Consultation Response from Conservation & Design

2021/93644 Low Farm, Wakefield Road, Flockton, Huddersfield, WF4 4BB

Erection and operation of grid-connected solar photovoltaic farm, with ancillary infrastructure and landscaping and biodiversity enhancements

Date Responded: 27/01/22 Responding Officer: NRG Responding Ref:

Title: Viewpoints

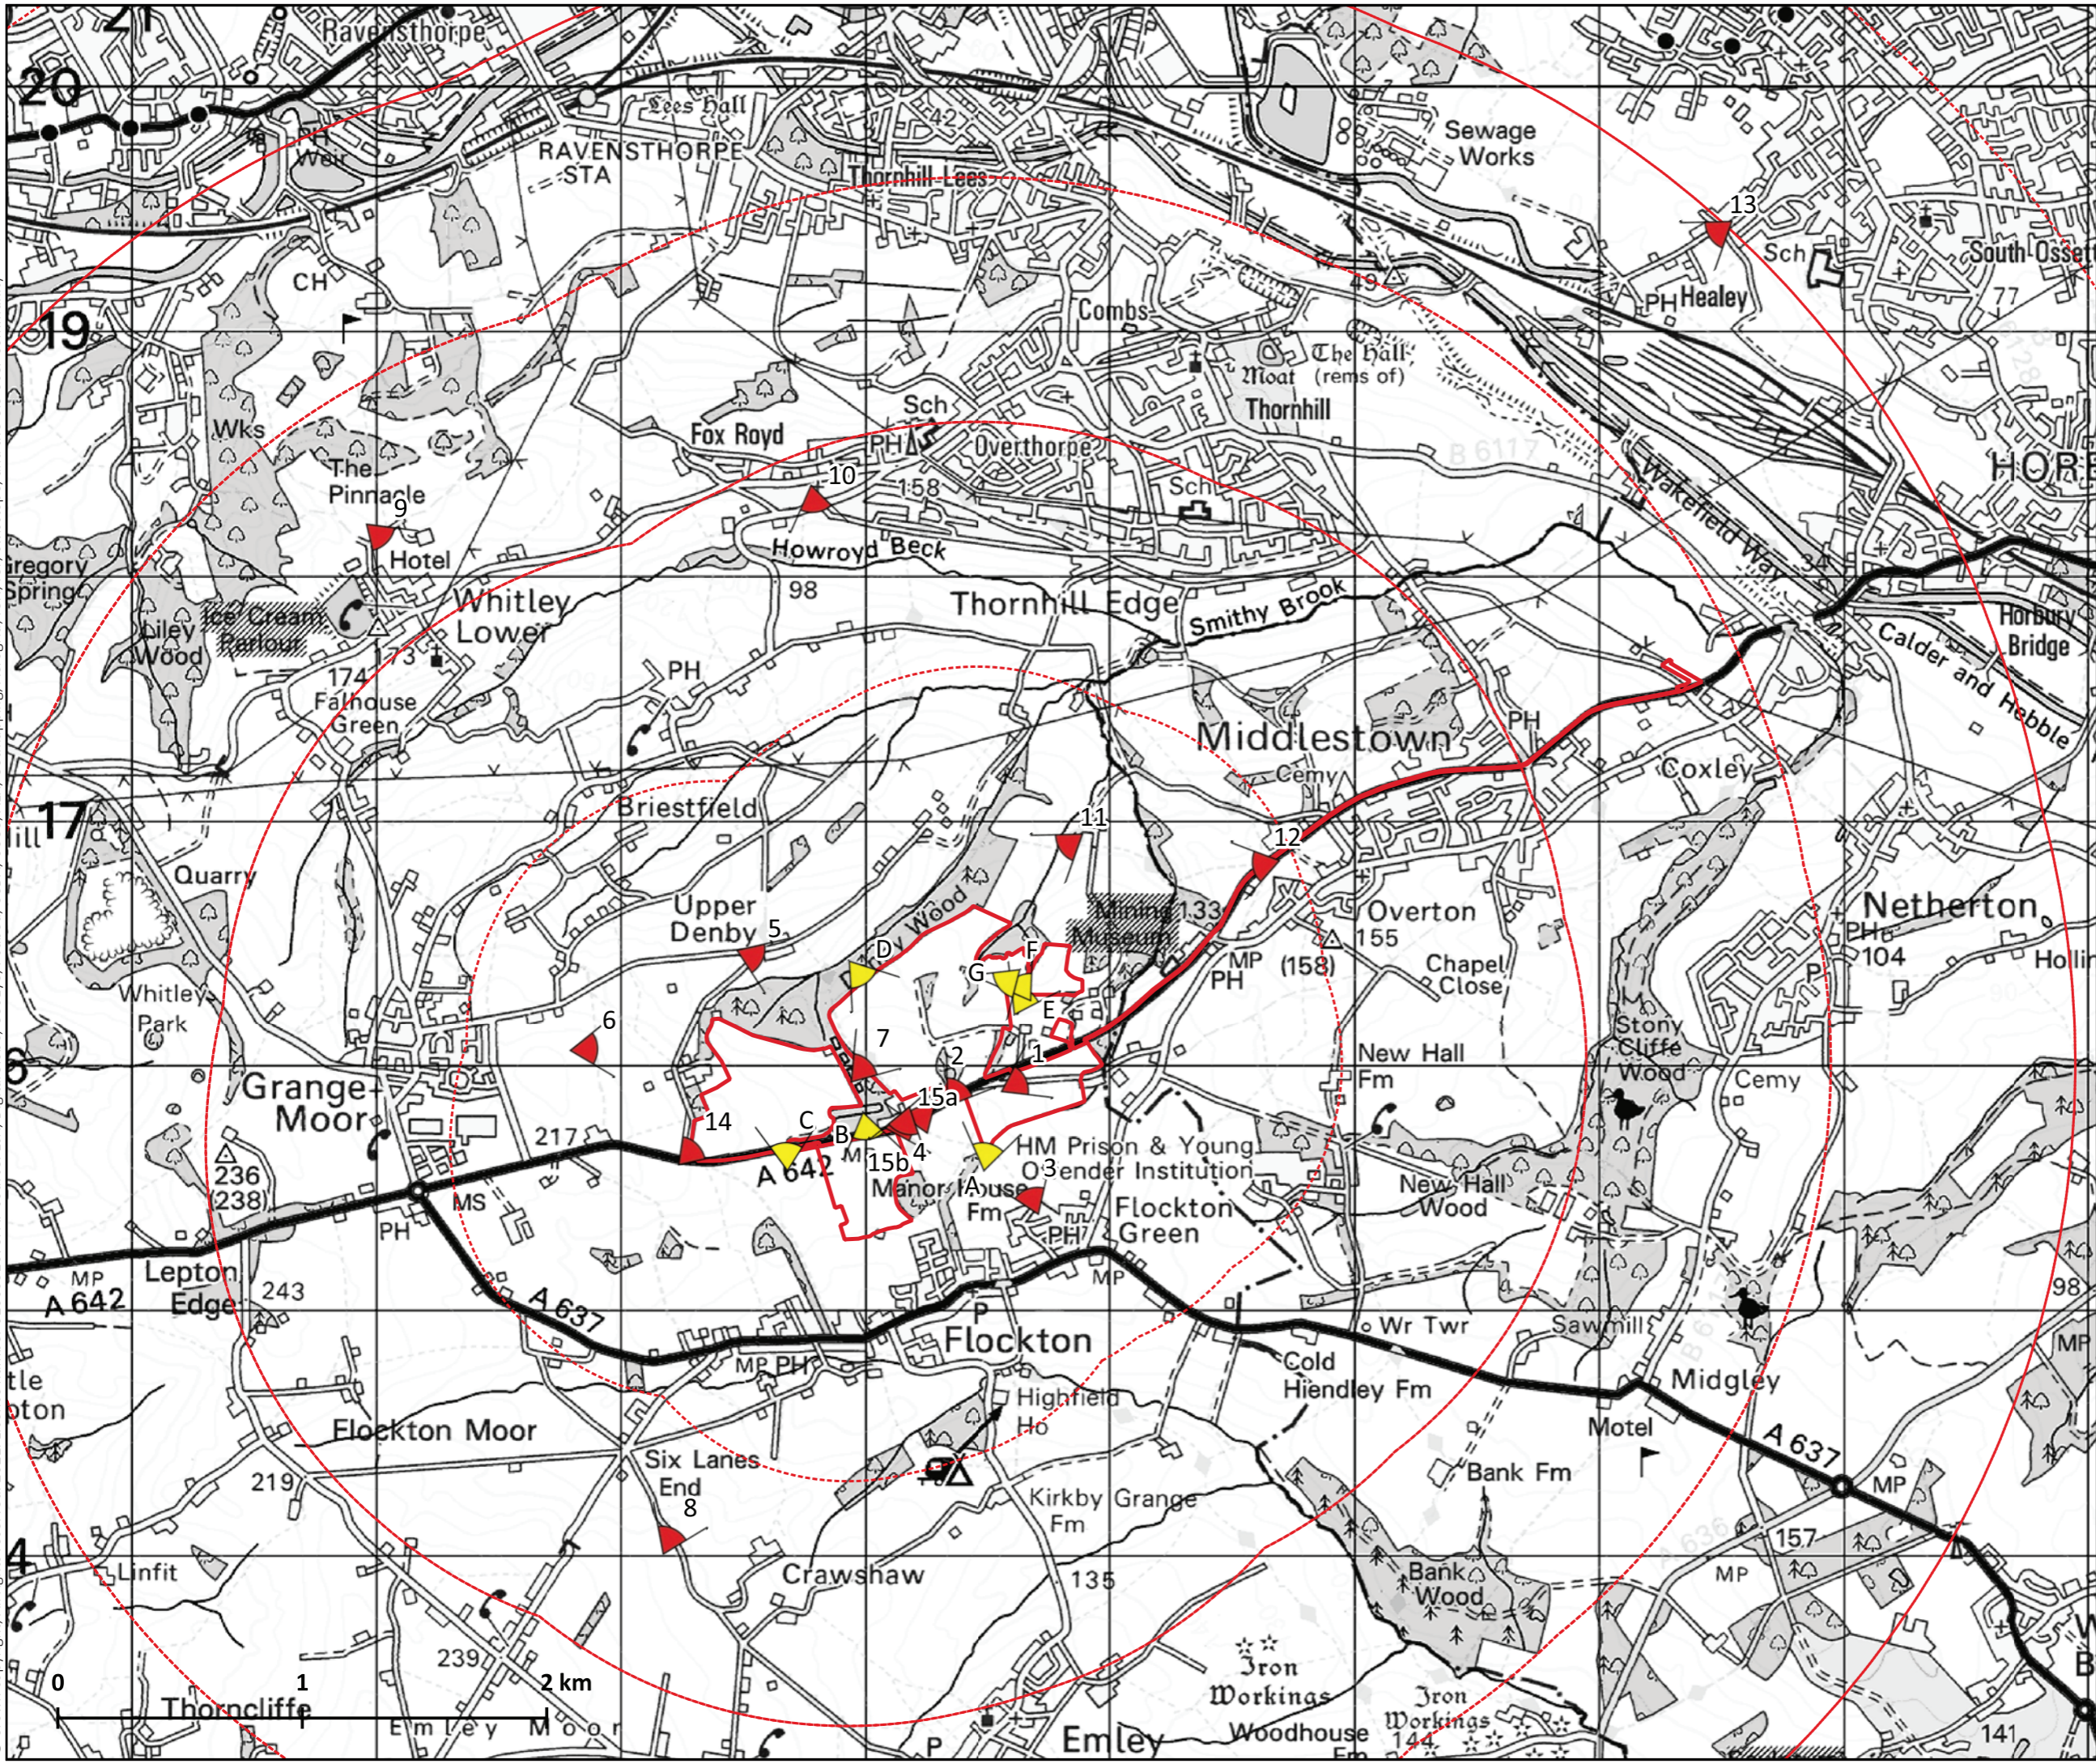
- The limited illustrated viewpoints in the LVIA do not demonstrate evidence how the expansive PV array will be viewed across the rolling landscape proposal, particularly from the north. The proposal should reveal the extent of the impact so that the balancing public benefits can be fully measured. Further photomontages from elevated, distant viewpoints and the PROW network should be required, with the effects of the mitigating landscape planting clearly demonstrated.
